UPPER PETROGLYPHS TIA COMMENTS
Comments Recieved in 2022

FIGURE 3
PHASE I

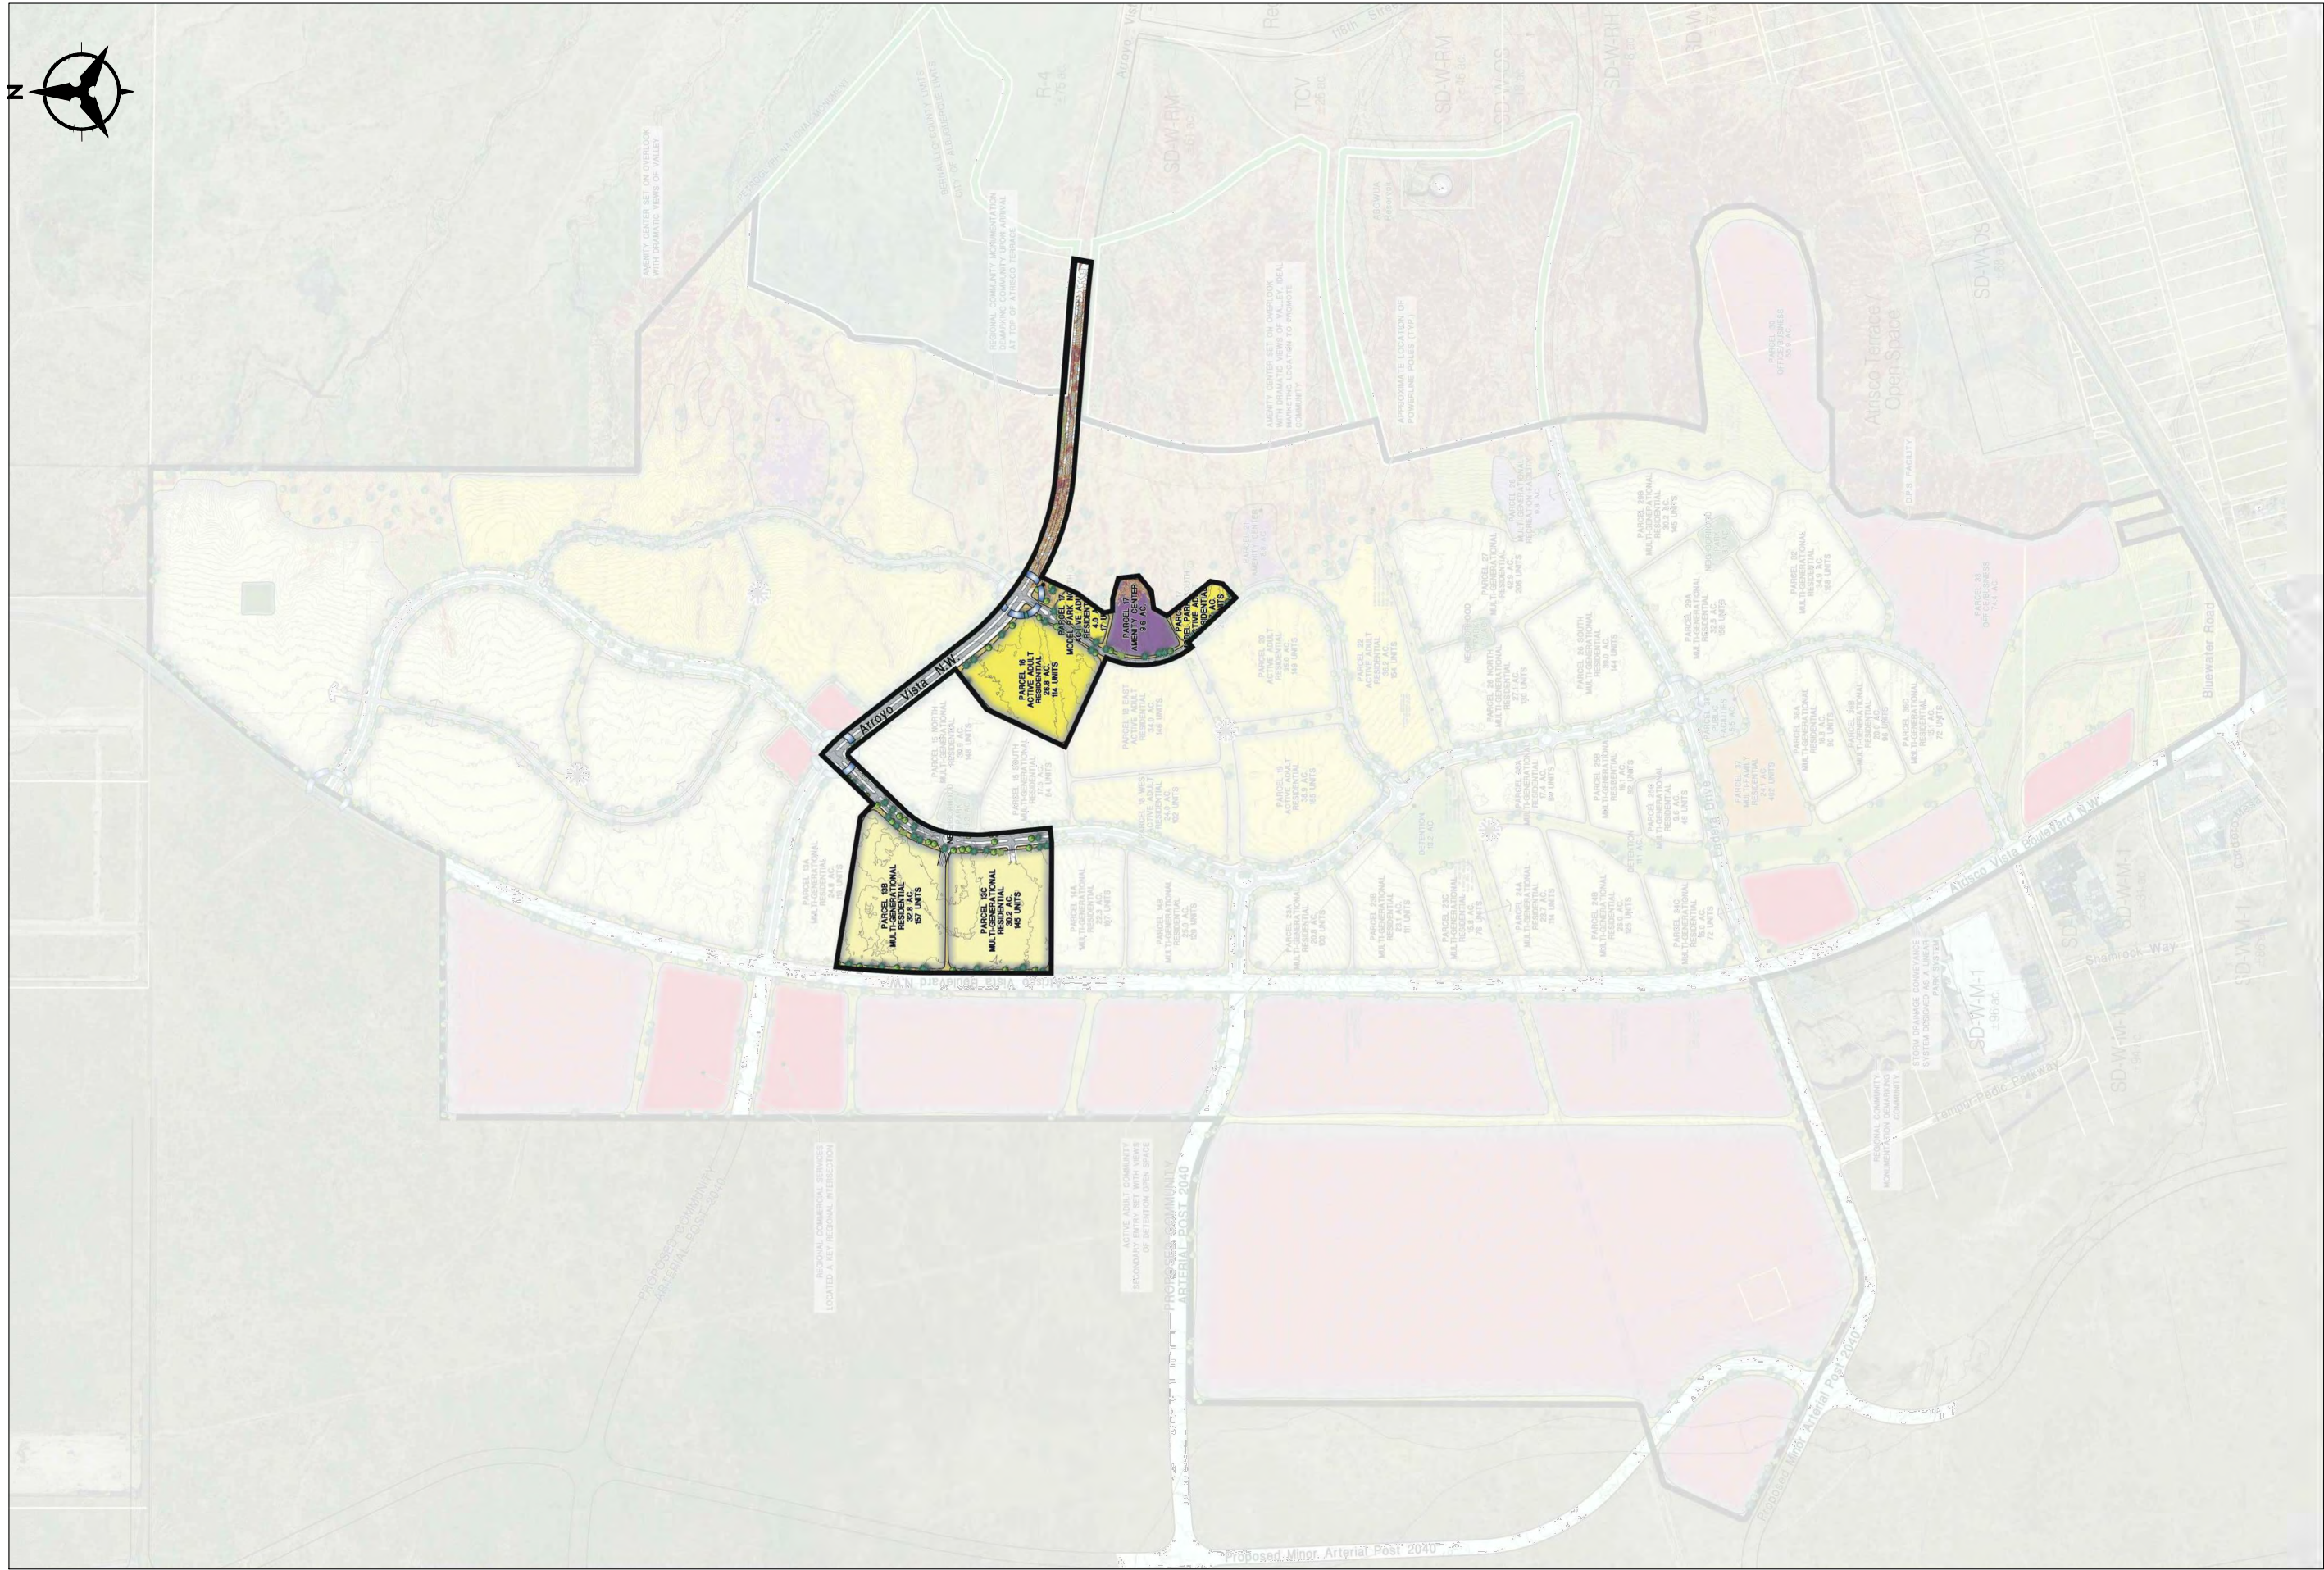
general	2034 Del Webb Prkwy recommend correction on construction sections	Bernalillo County	AG	Added	CDV
					CDV
5	2027 Build, first sentence of section missing language	Bernalillo County	AG	Revised	CDV
28	Arroyo Vista to Atrisco Vista, Figure 3 to reflect connection by Ph1	Bernalillo County	AG	Arroyo Vista connected by phase 1 is correct. Added figures showing recommendations by year	CDV
29	2034 Arroyo Vista 2-lane (ex) or 4-lane (rec), which one?	Bernalillo County	AG	Arroyo Vista recommended to be 2 lane through build out	CDV
76-79	Ladera Parkway > Ladera Drive	Bernalillo County	AG	Updated	CDV
126-127	Reflect language for 2034 Estancia/Ladera on correct lane config (rec?)	Bernalillo County	AG	Updated	CDV
					CDV
general	review development pace, adjust infrastructure improvement to correlate build changes	City of Albuquerque	AG	Done	CDV
general	construct traffic signals at recommended intersections	City of Albuquerque	AG	Done	CDV
